Our Ref: **AW/85/12/T**
Your Ref:

Town & Country (Trees) Regulations 1999 (as amended)
Application for Works to Tree(s) on trees subject to a Tree Preservation Order (TPO)

Development Remove 3 metres from crown of 1 no. Twisted Oak tree which is hollow. Trim 1 metre from crown of 1 No. Twisted Oak beside it.

Location Headland House Strange Garden Estate Bognor Regis

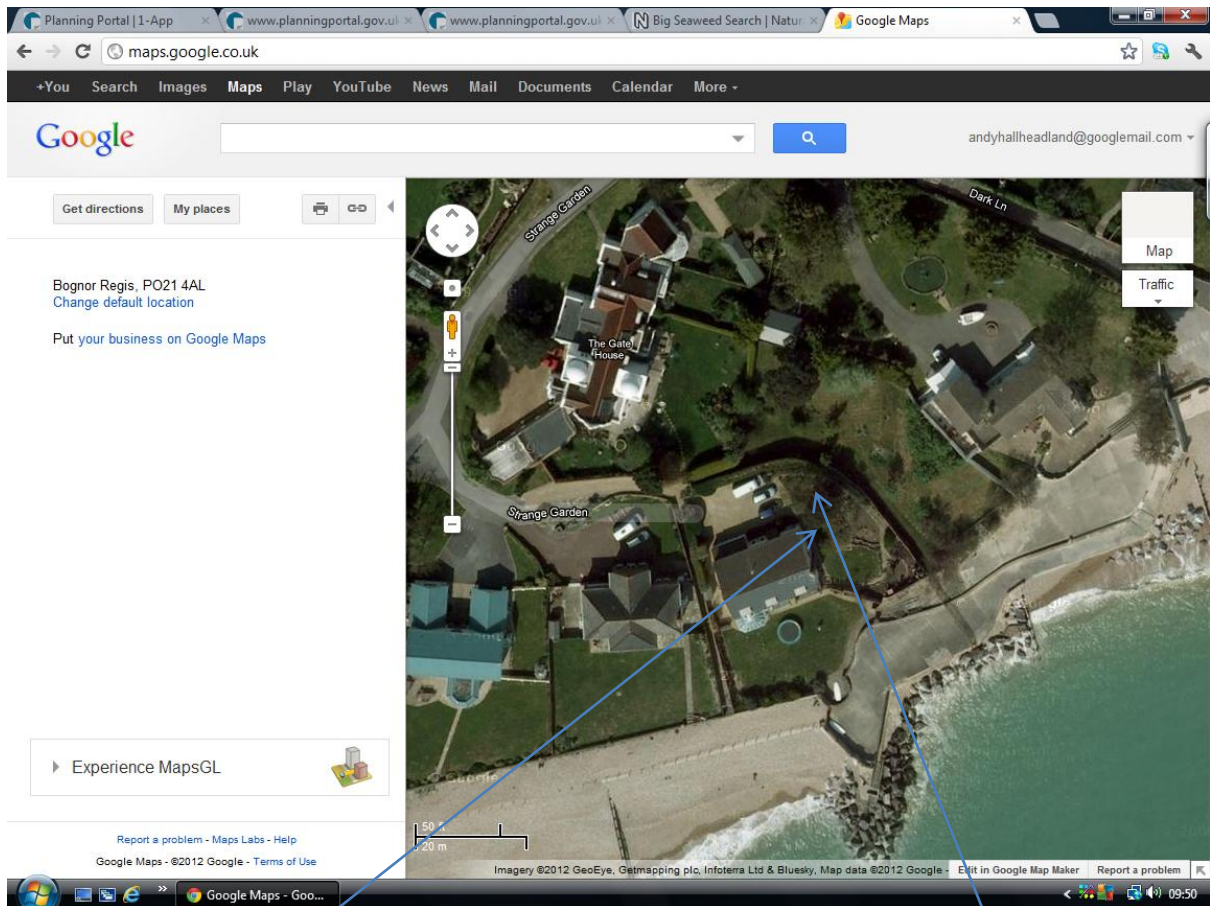
Please provide an amended sketch plan to clearly identify the position of the trees within the garden curtilage in accordance with the guidance notes on our website.
